Re: Planning Application 19/0499

Address: Kitchen Green Farm Preston Road Ribchester PR3 3XL

Description: One new double-sided sign (Resubmission of 3/2019/0177).

R Seed, Kitchen Green Farm – Site Plan 2

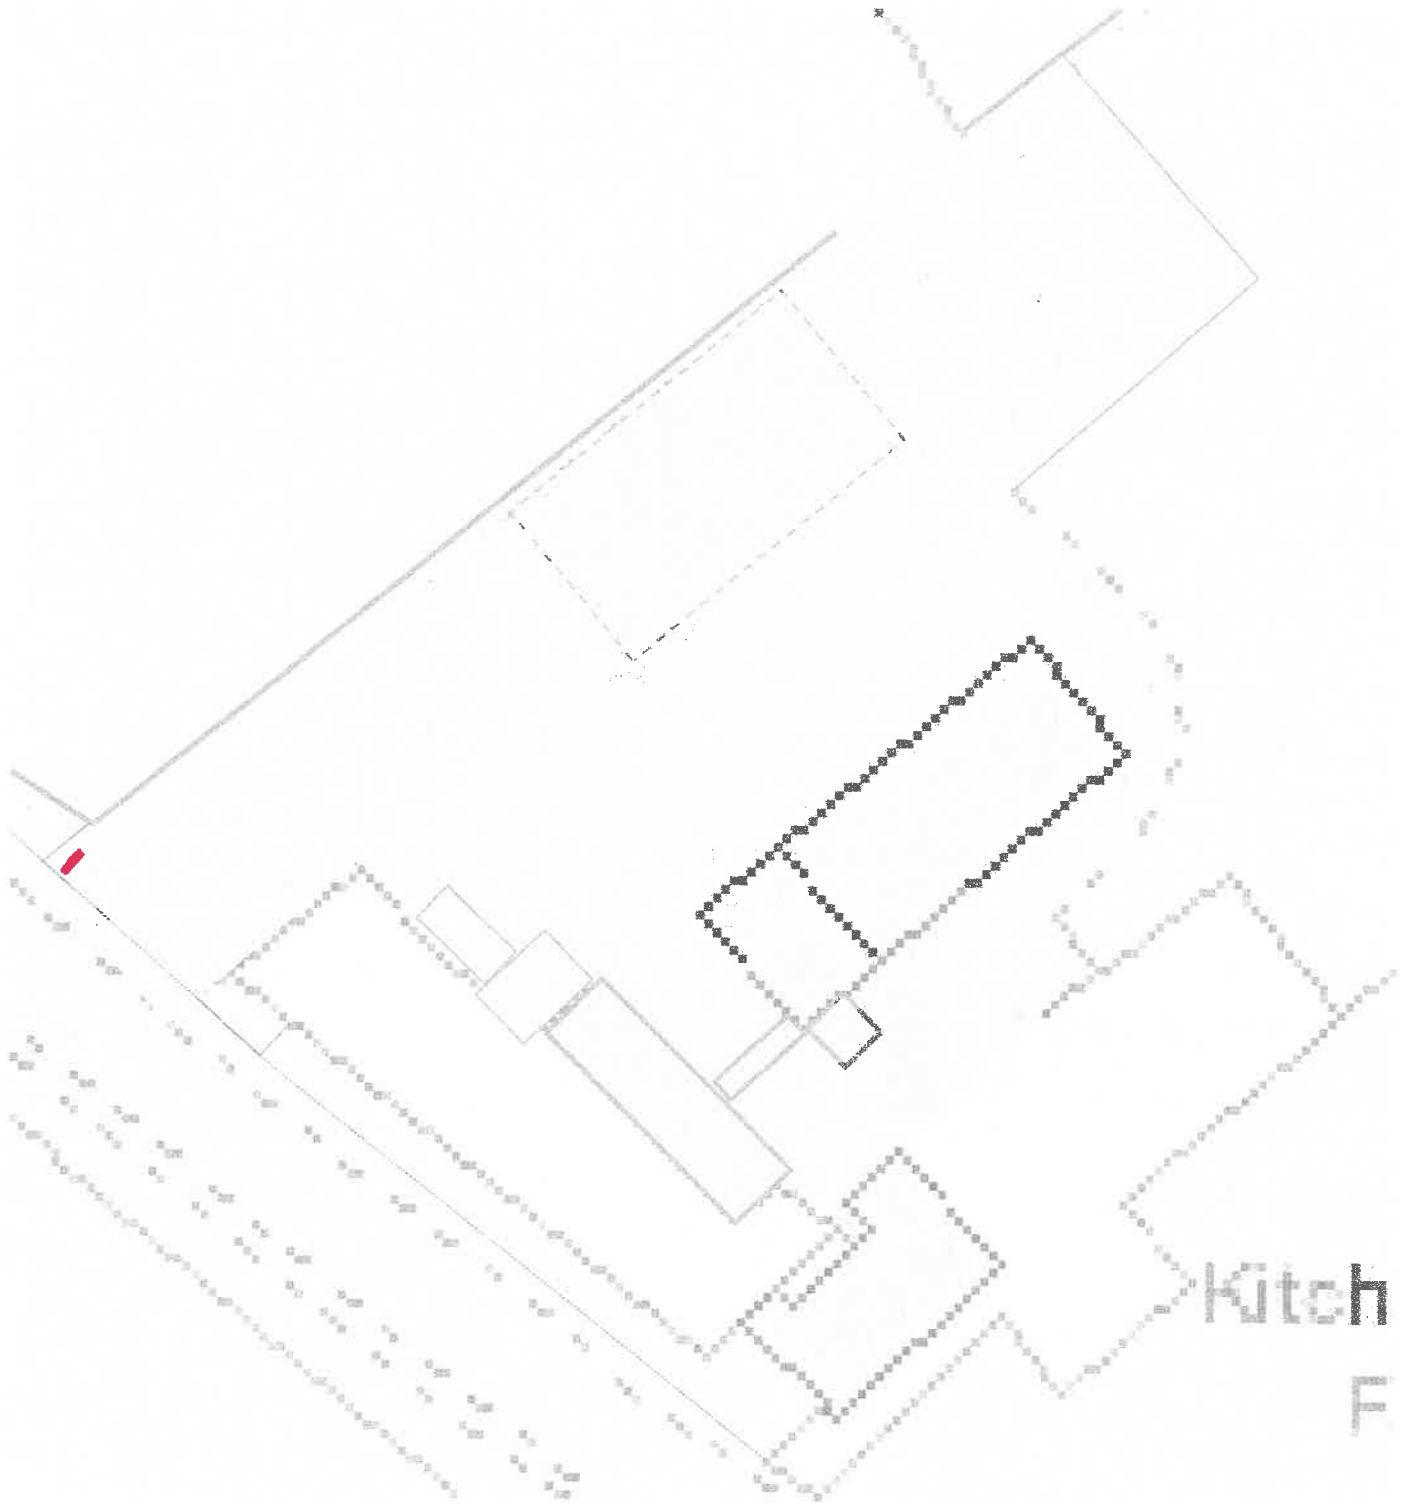
With respect to this application we would not wish to raise any objections to the principle of the signage. However, there is a concern regarding the lack of detail of the location of the sign.

A further plan shown the sign location would be required, this plan should show the position in relation to the site access and the kerb line. This is to ensure that the sign is not placed in the visibility splay for the previously agreed access to premises.

R Seed, Kitchen Green Farm, Ribchester – Planning Application – Plan 3 Elevations

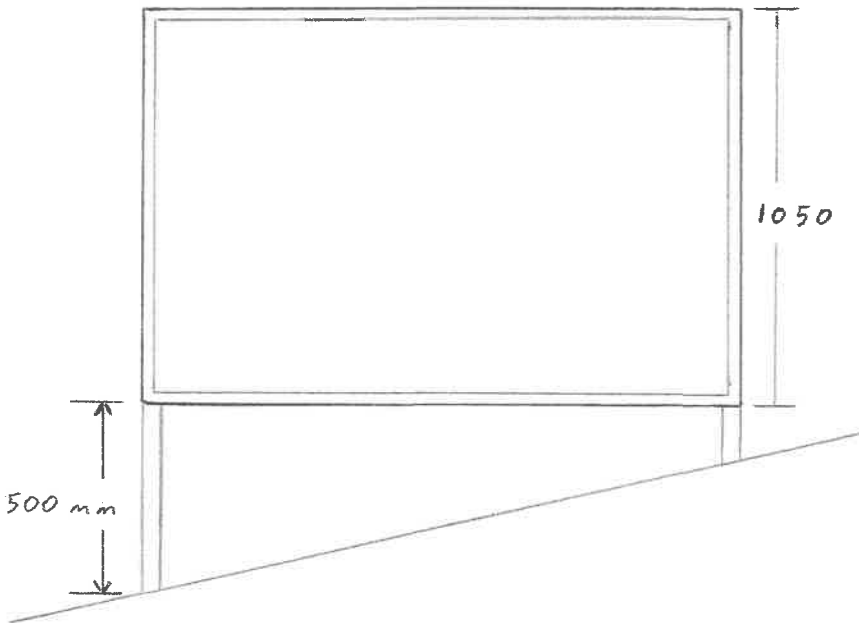
Based on the sizing of the small case letters (x height x=125mm), it would appear that the sign is being designed to be read at the national speed limit. As this is a sign to locate a business then it should be assumed that a person travelling to it would not be traveling at the national speed limit but a lower speed. Should the sign be considered to be too large then a consideration of the use of a smaller x height of x = 100mm could be given.
